Thurrock Flexible Generation Plant

Deadline 2 – Applicant’s Response to the ExA’s First Written Questions

Figure 1.1: Air Quality Management Areas and Modelled Sensitive Receptors.

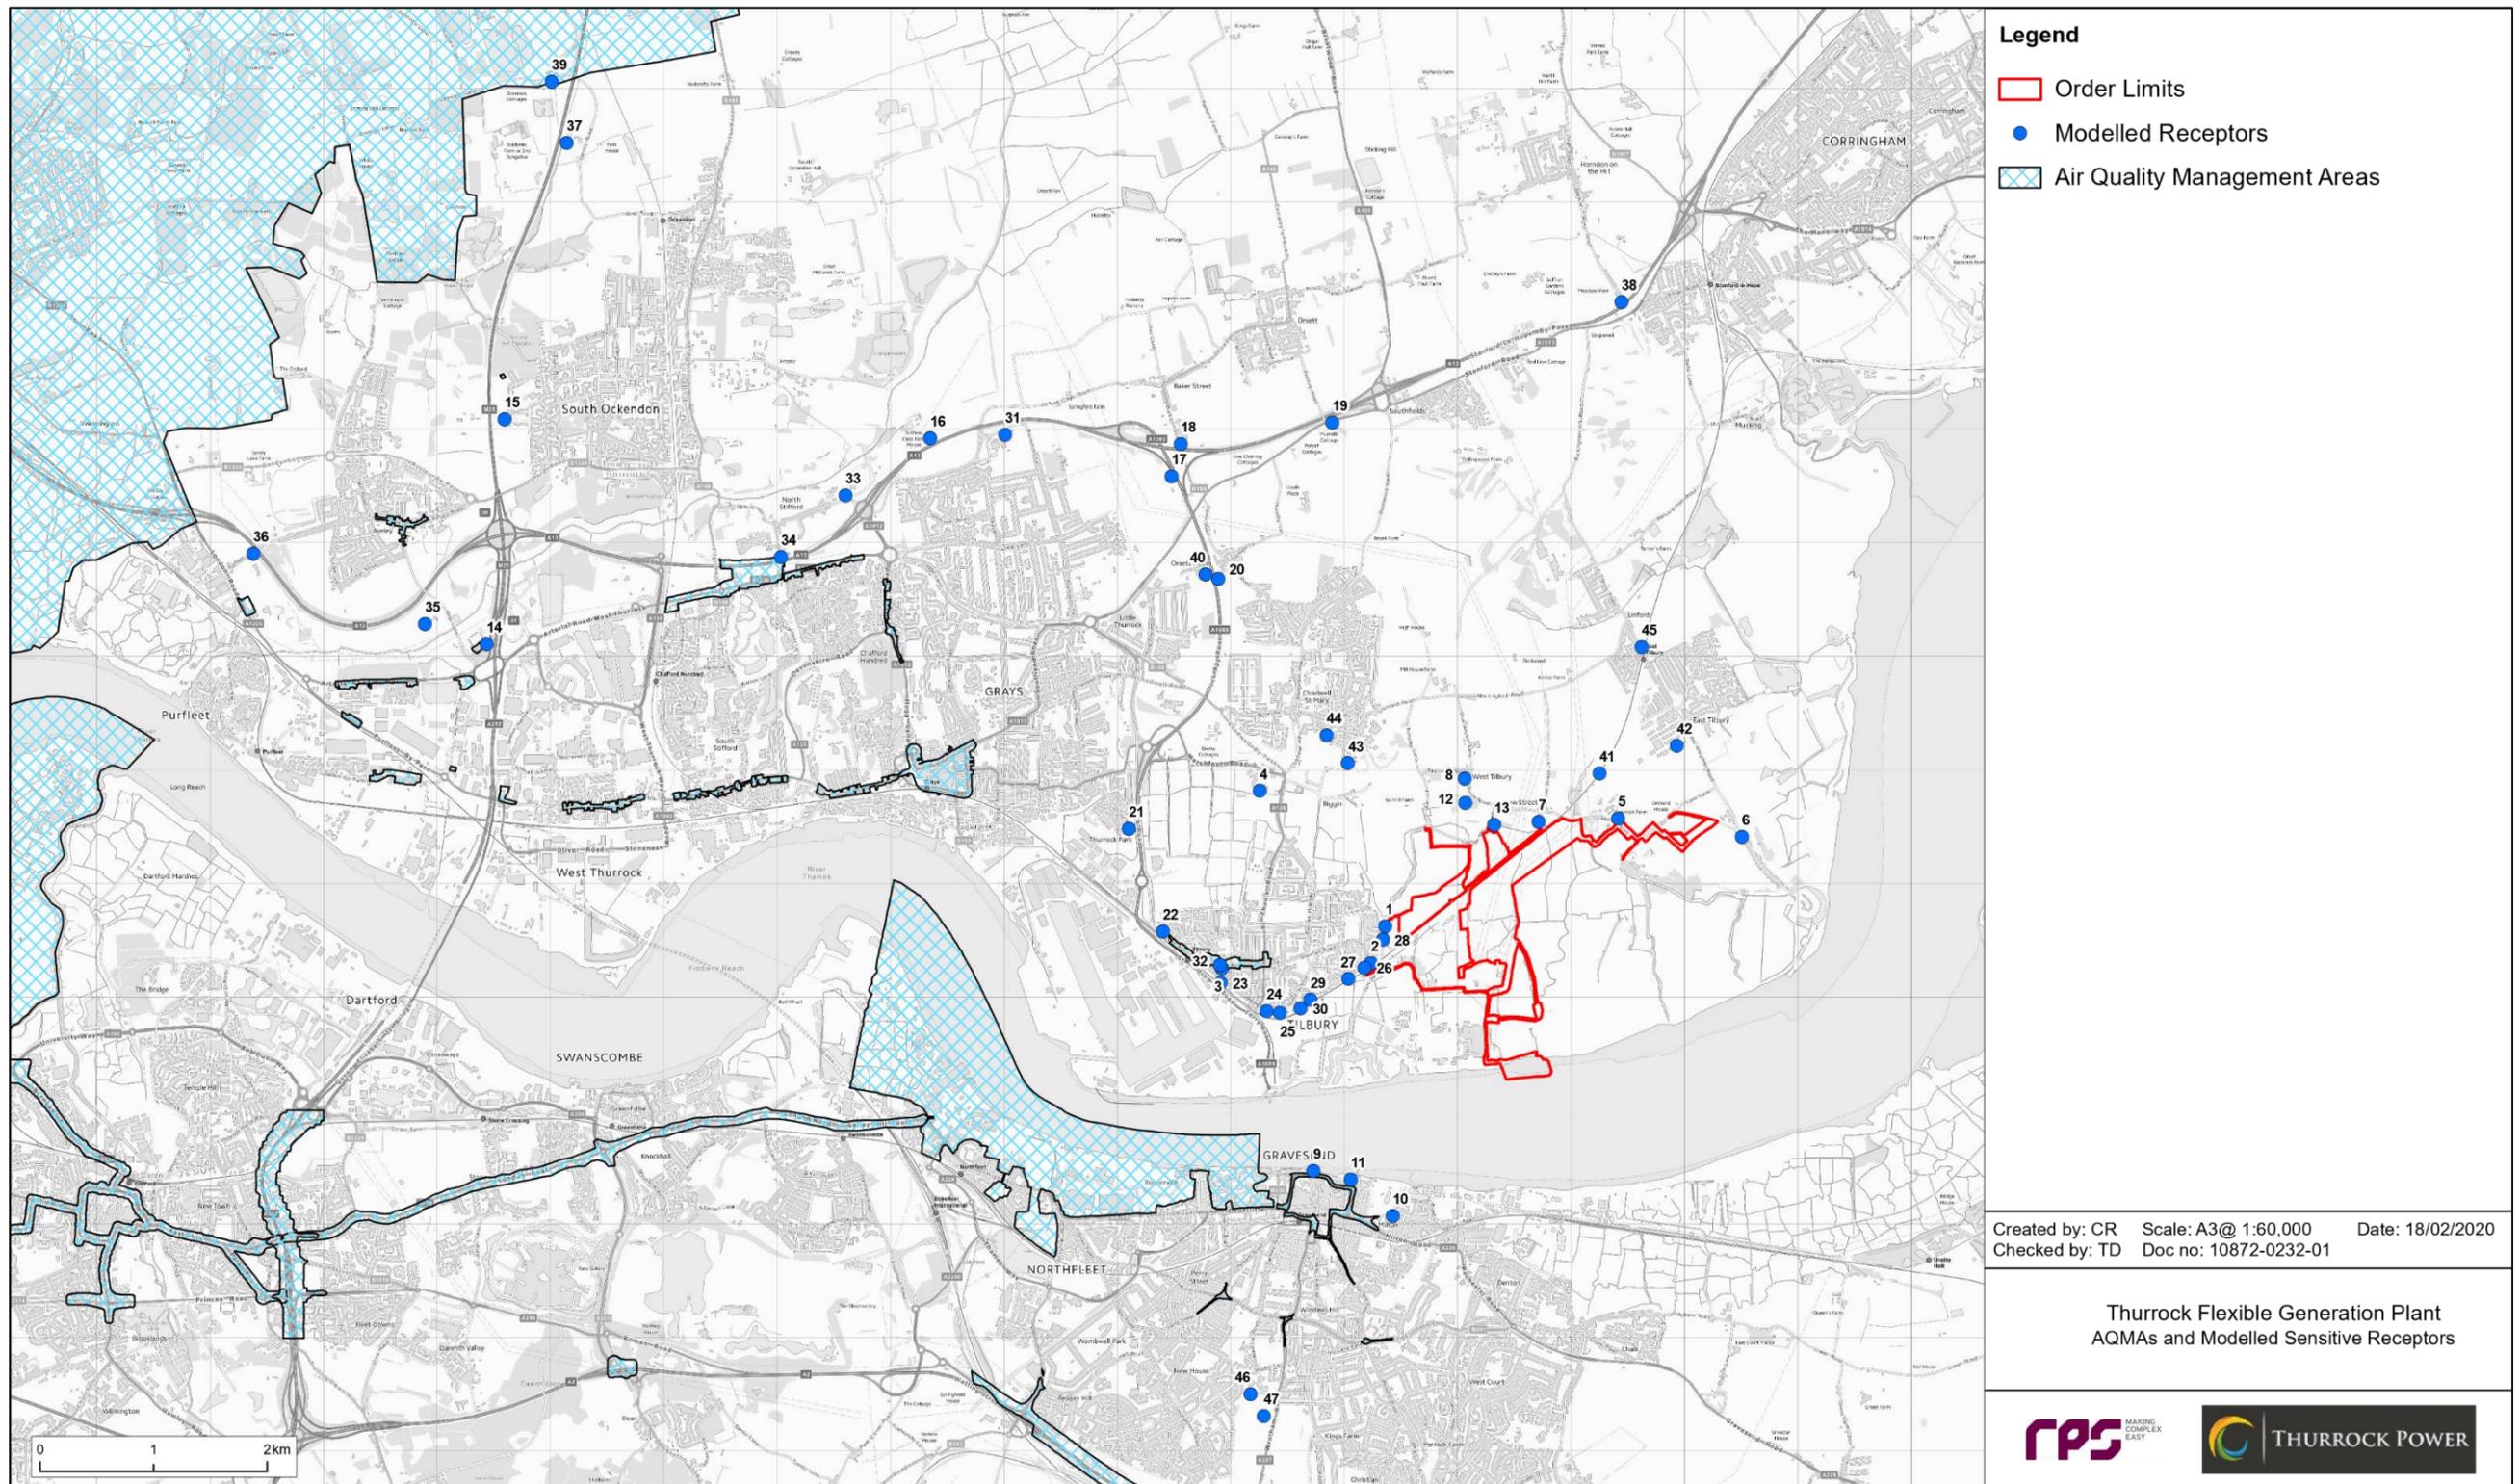
1.1.4	<p>Table 2.4 and Figure 1.1 of ES Chapter 12 display the modelled sensitive receptors. Please explain why only two receptors (Receptor 22 and 32) have been modelled within Thurrock Council's Air Quality Management Area (AQMA) 24 and why the eastern extent of the AQMA does not have a receptor despite it being the closest part of the AQMA to the Proposed Development.</p>	<p>Unless there are very few receptor locations in an assessment study area, it is not usual or realistic to assess every discrete receptor location that could potentially be affected; it is therefore usual to choose a limited number of receptor locations that are broadly representative of the general characteristics of particular areas, in locations where people are exposed for the relevant periods and where the normal day-to-day background influences for the area can be expected. This pragmatic approach is robust provided that the chosen receptor locations encompass the major factors that make them suitable for characterising exposure in their immediately-surrounding areas.</p> <p>That is the case in this study: it is not possible to model every receptor so representative sensitive receptors were selected at properties where pollutant concentrations and/or changes in pollutant concentrations were anticipated to be the greatest.</p> <p>Receptors 3 and 32 are within the Tilbury AQMA and are located closer to the roads used by the Tilbury2 development than the eastern part of the AQMA. It was expected that at this distance from the stacks, the road contribution would be higher than the stack contribution (Receptor 22 is located approximately 60 m west of the AQMA).</p>

Figure 4.1: Construction Dust Assessment Buffers.

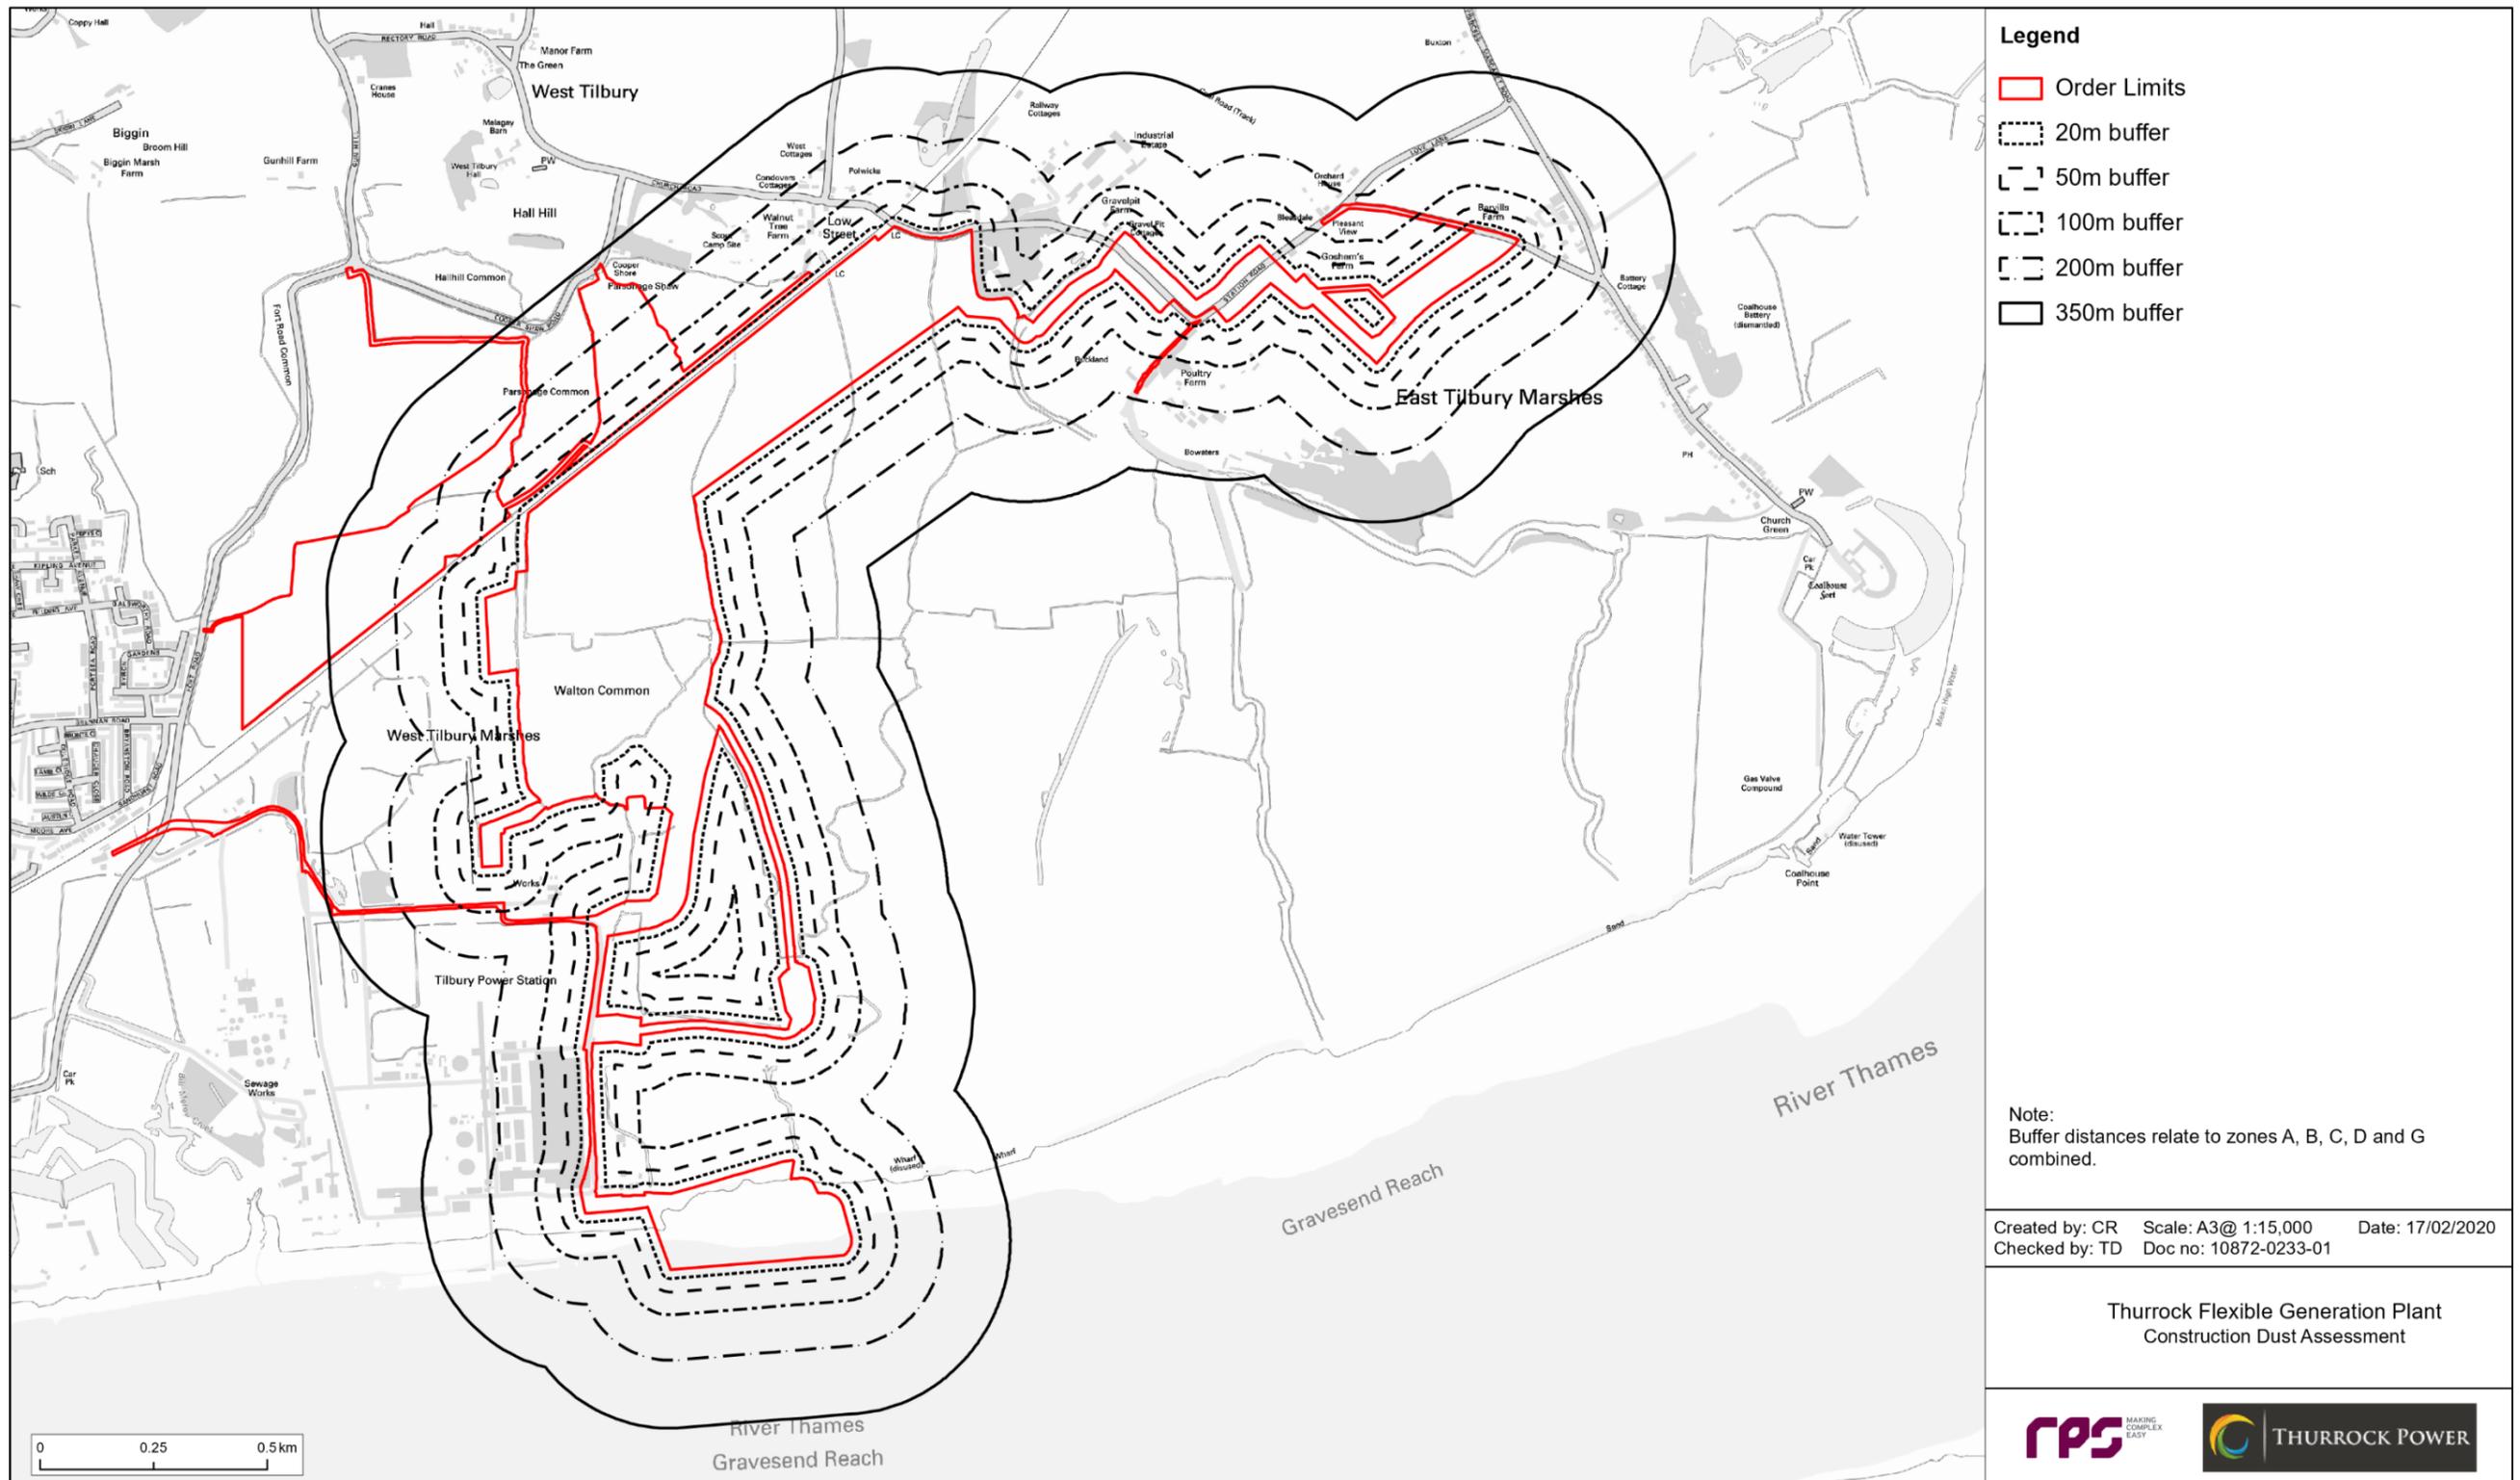
1.1.2	<p>Paragraph 4.1.16 of ES Chapter 12 states that receptors have been included at distances within 20m, 50m, 100m, 200m and 350m of the site boundary (excluding Zone E). However, Figure 4.1 shows that other Zones have been excluded. Please confirm the study area used and provide justification for any other development zones excluded.</p>	<p>Figure 4.1 shows the study area used for the assessment of potential effects from dust during construction. Paragraph 4.1.16 should have also mentioned that earthworks and construction activities are not expected at Zone H (existing private road for access). Similarly for Zone F (area for habitat creation) the works would be limited to topsoil strip and some pond/hummock digging within agricultural land. These areas were therefore excluded from the assessment of dust during the construction phase. The buffers shown in Figure 4.1 are correct.</p>
